Recommendation Report for Planning Permission for Works or Extension to a Dwelling

REF NO: BE/78/20/HH

LOCATION: 111 Stroud Green Drive
Bersted
PO21 5SZ

PROPOSAL: Single storey rear extension including demolition of existing conservatory and single storey side extension.

Existing Floor Plan

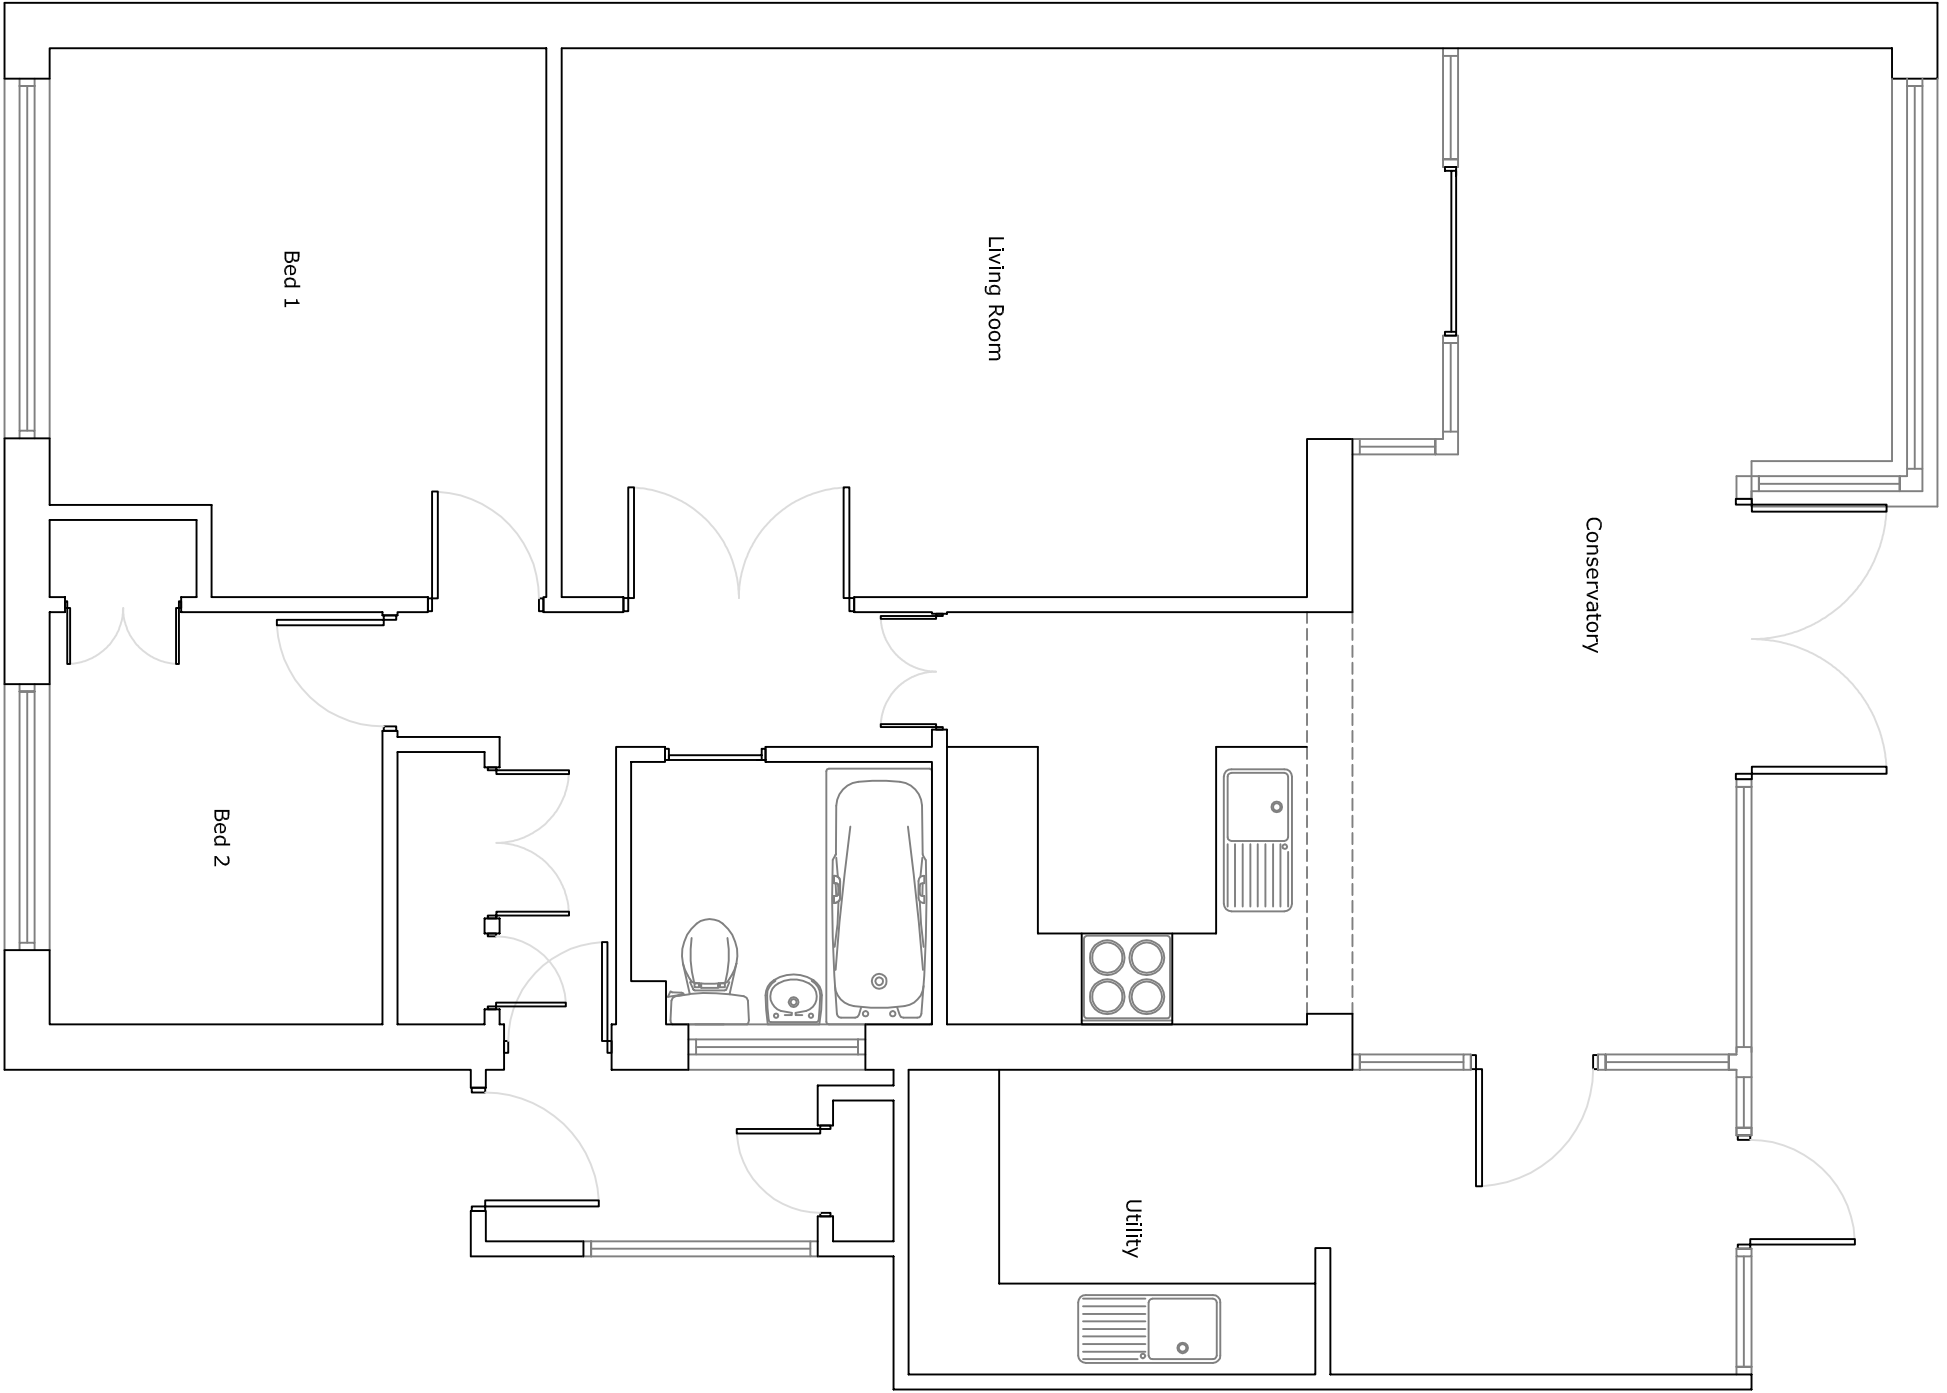
The host dwelling has a conservatory which runs along part of the rear, although varies in depth. This will be removed and replaced with a rear extension.

Proposed Floor Plan

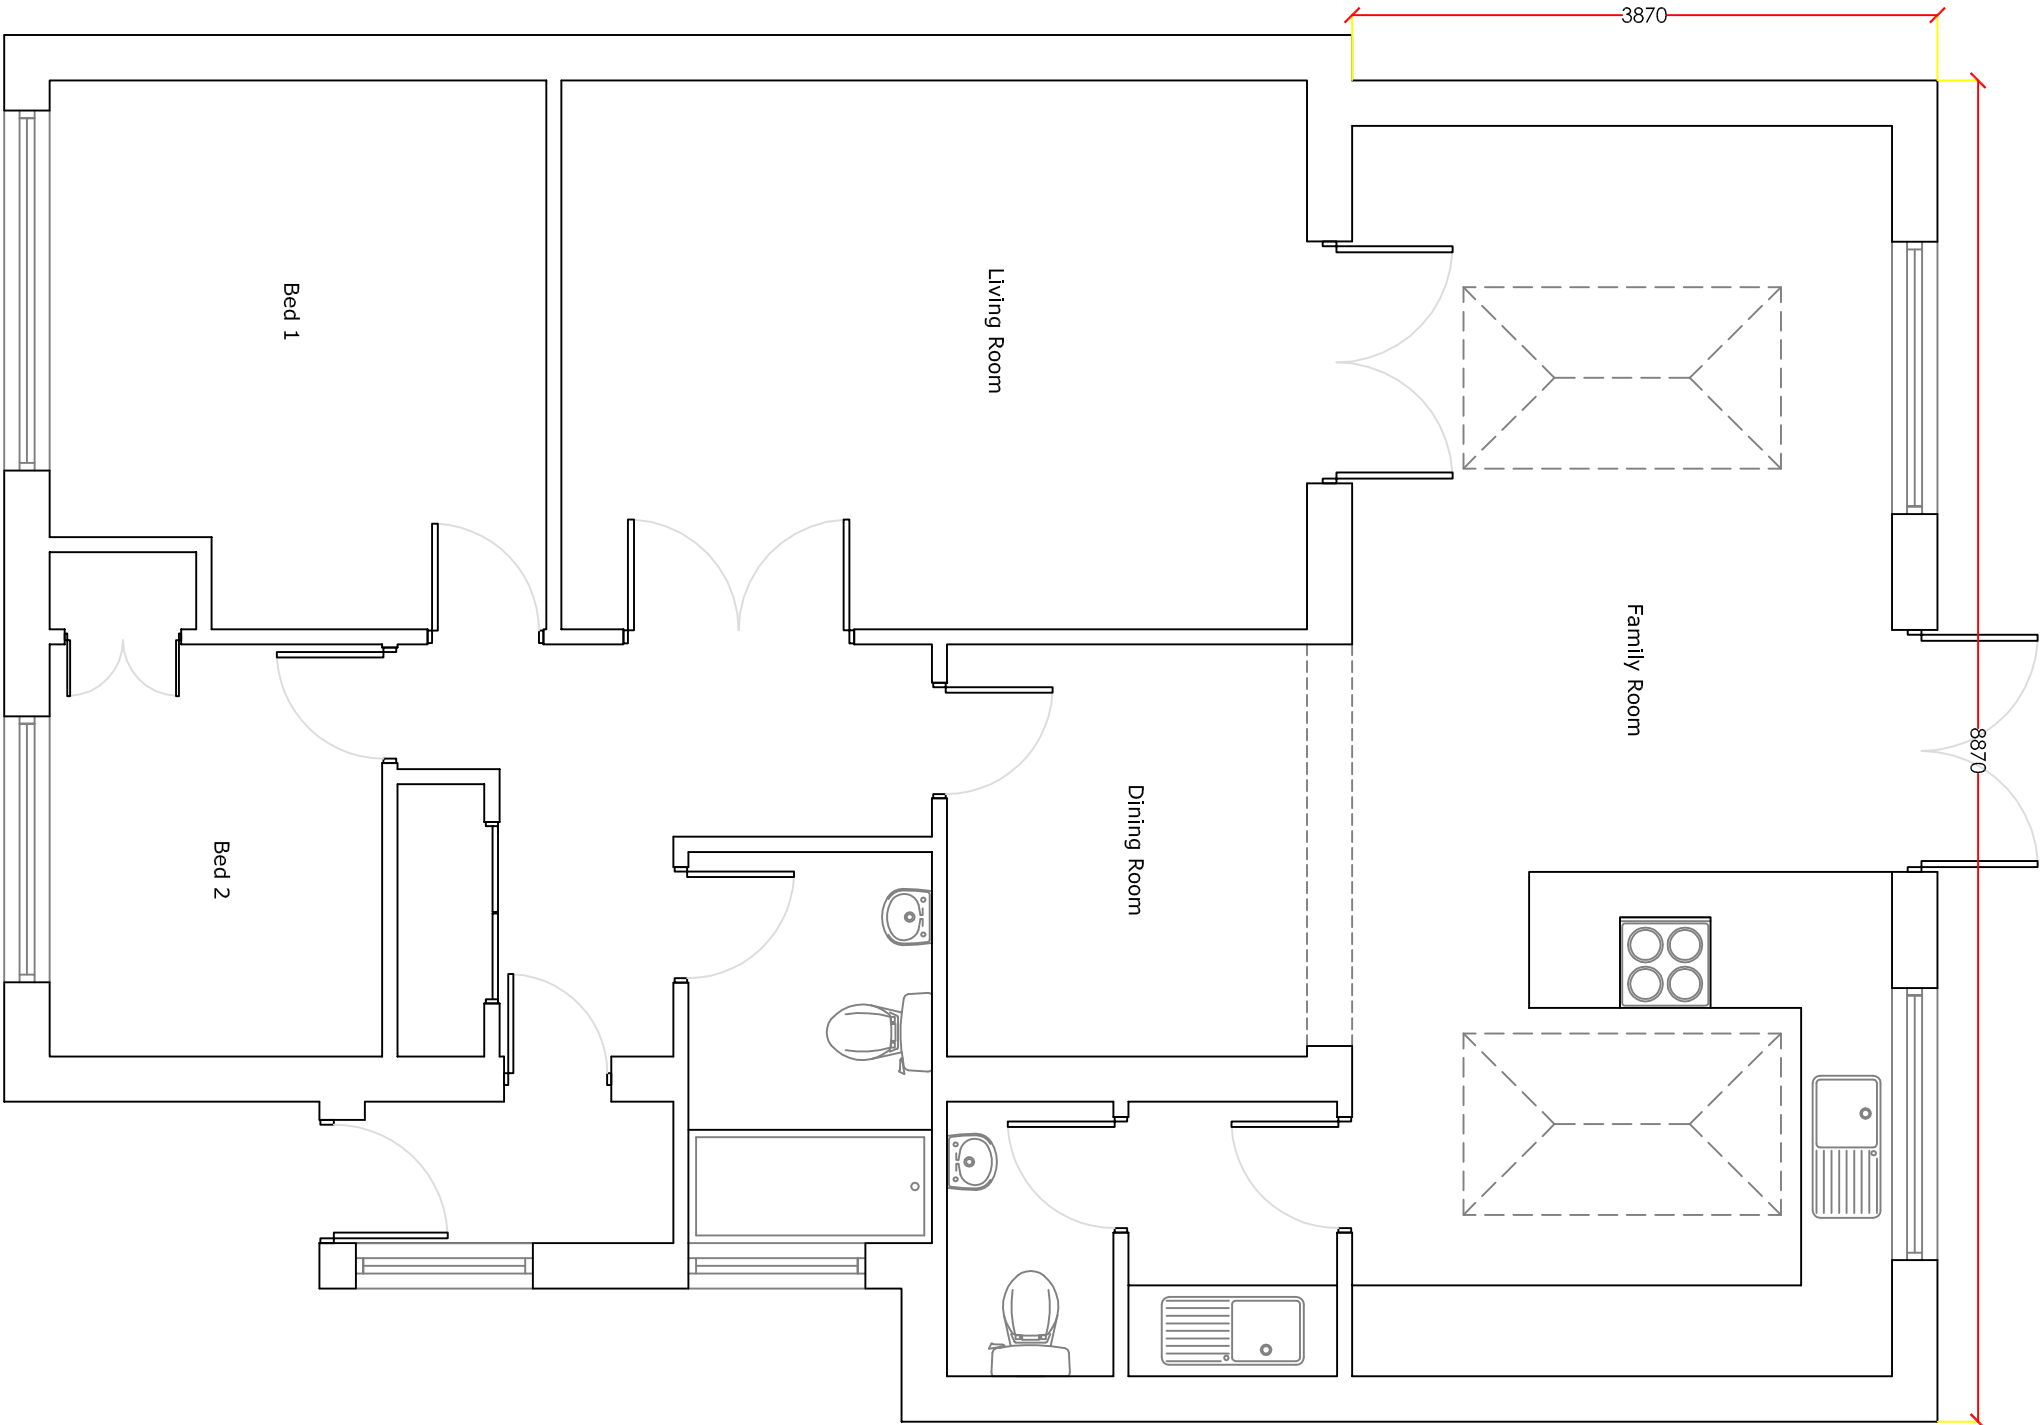
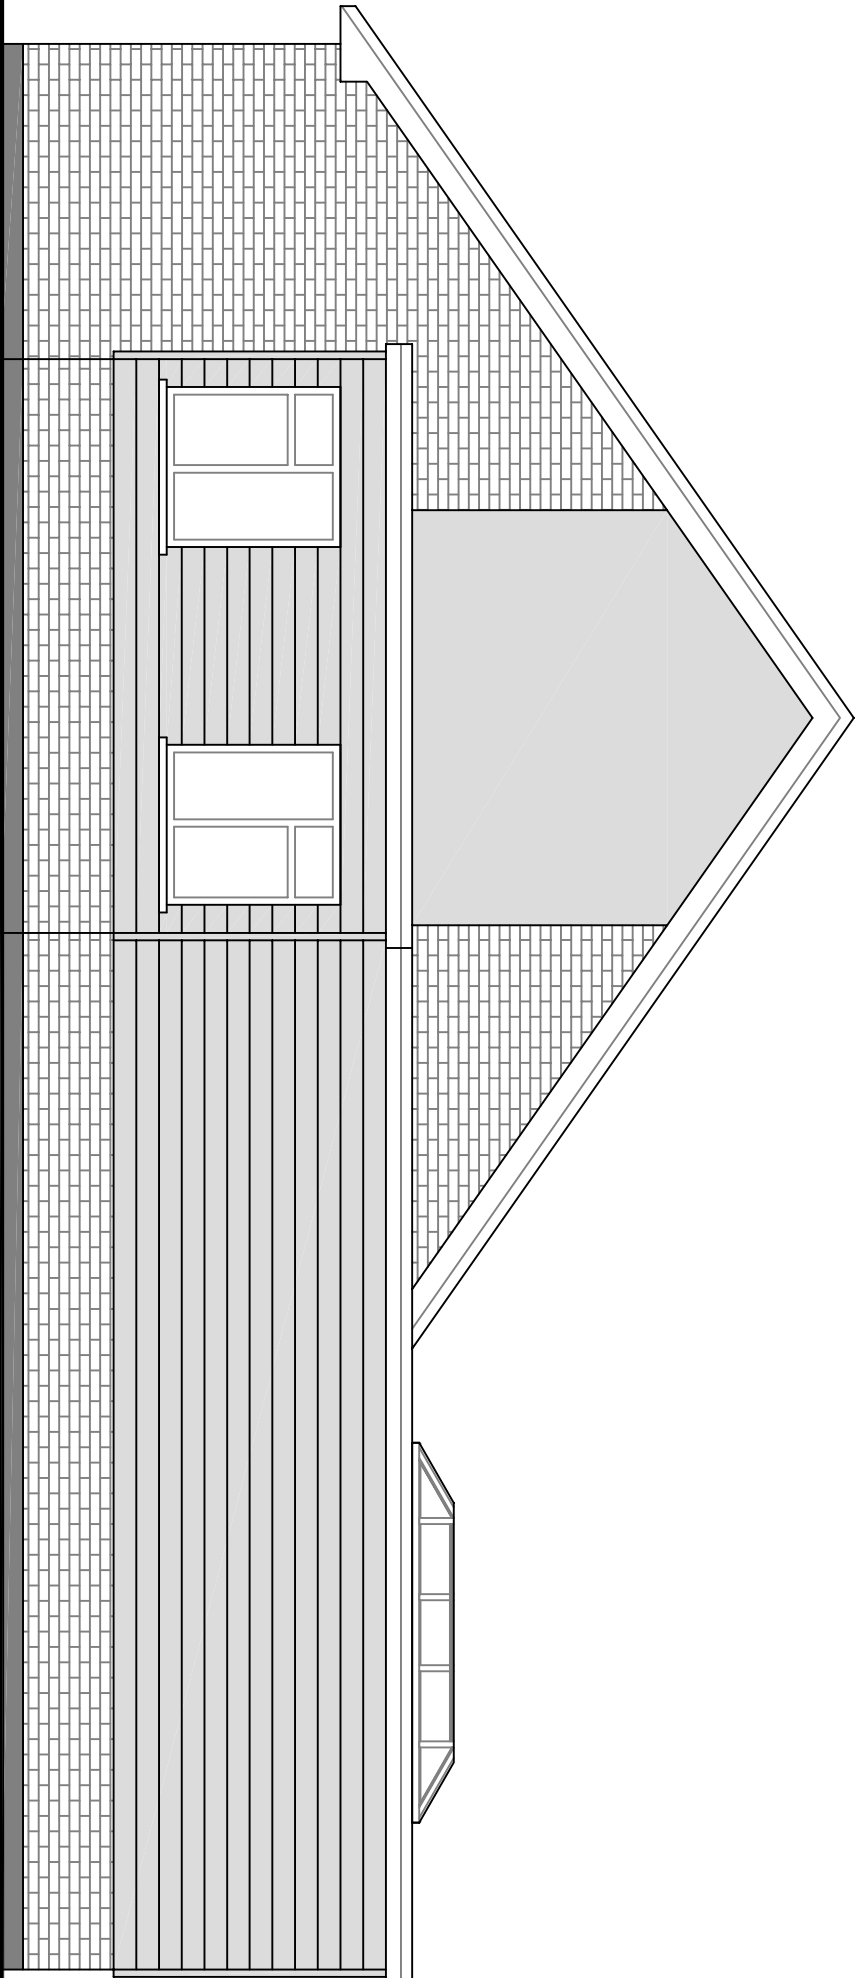
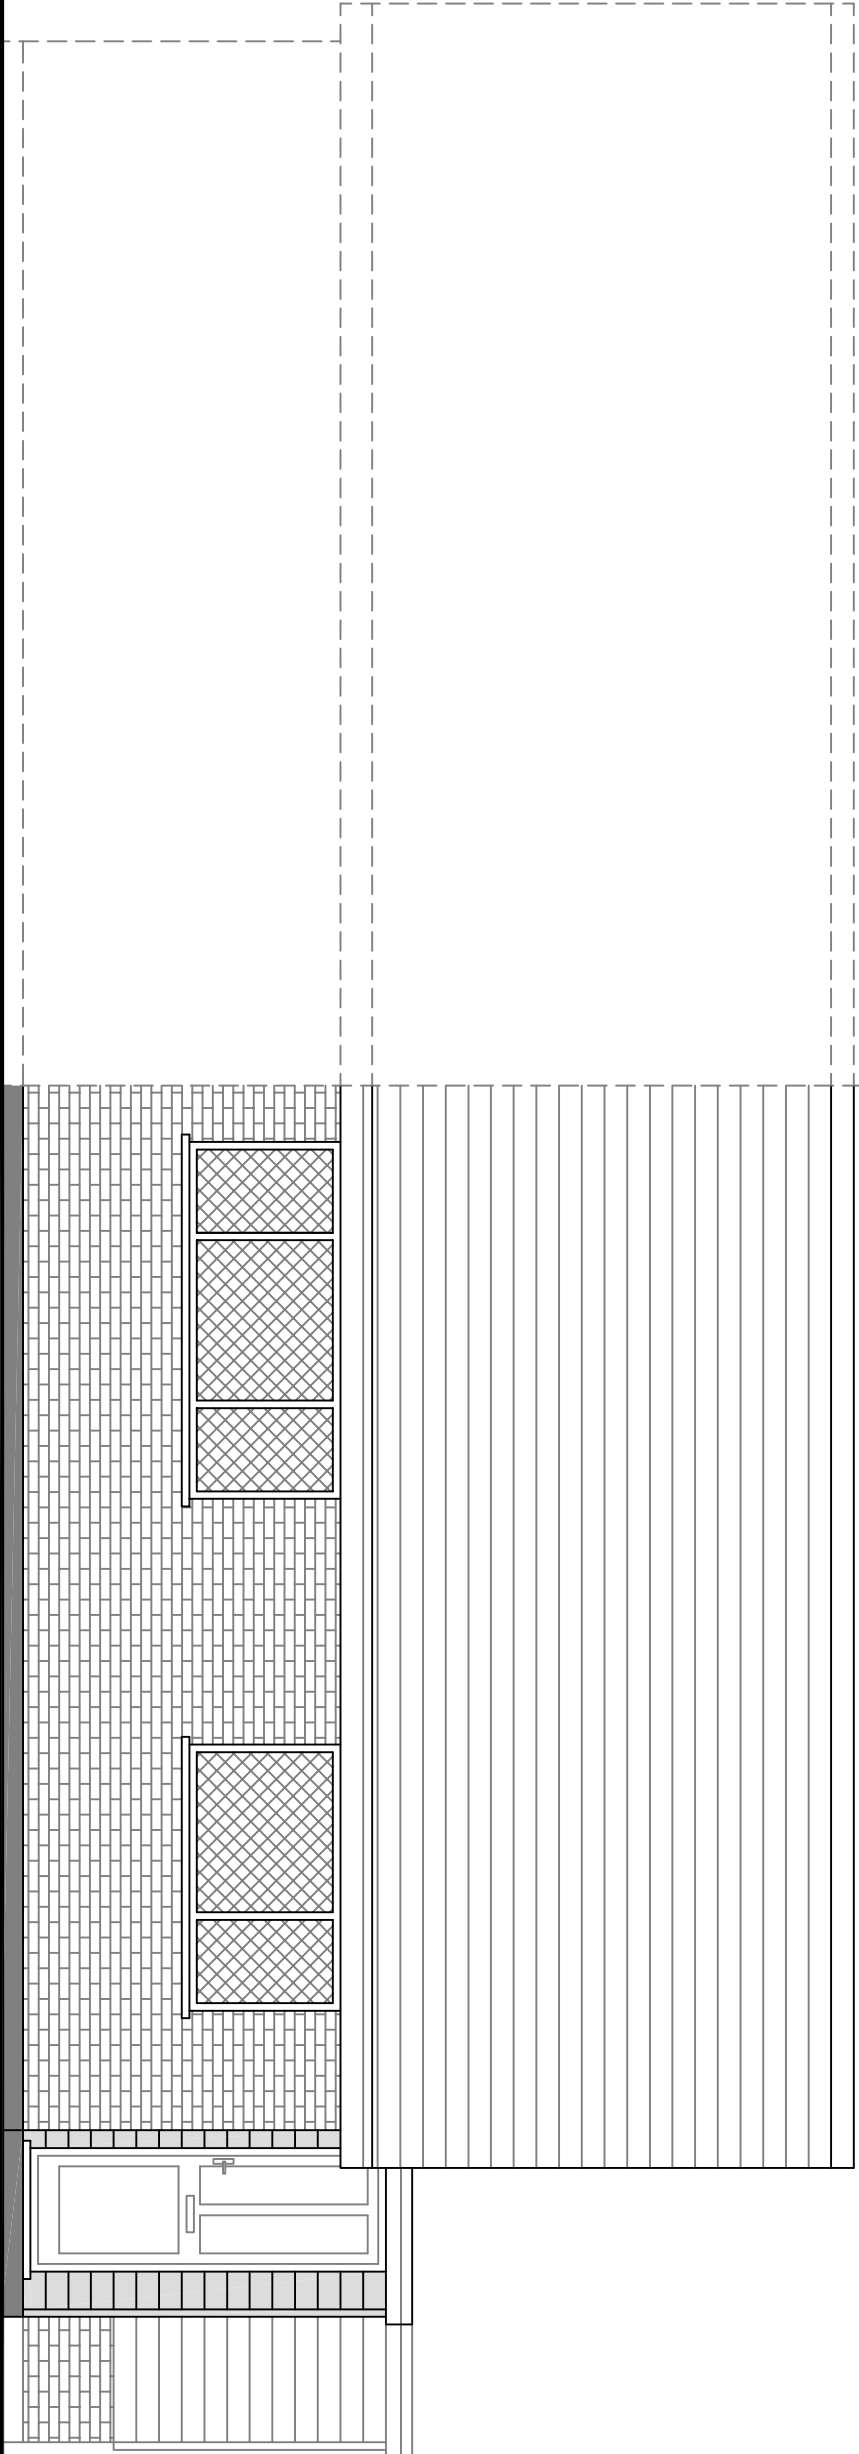
The proposal will have a depth of 3.87m which is an increase of around 1m than compared to the existing. It will have a height of around 2.5m to the eaves and 2.75m with a flat roof. There will also be two roof lanterns to a height of 3.1m.

The addition extends beyond the rear elevation of the neighbouring property and is likely to intersect a 45 degree angle. Whilst the extension is slightly taller than the existing conservatory, the depth of the conservatory to the eastern side is currently around 3.8m and the depth to this side does not increase and therefore the impact to this side by way of overbearing or overshadowing is not considered to significantly increase from that which is already achieved. An extension could be constructed to 3m under permitted development and the increase is not considered to result in a significant adverse impact.

There will be doors to the rear which will overlook the garden of the host dwelling and the proposal is not considered to give rise to additional overlooking.
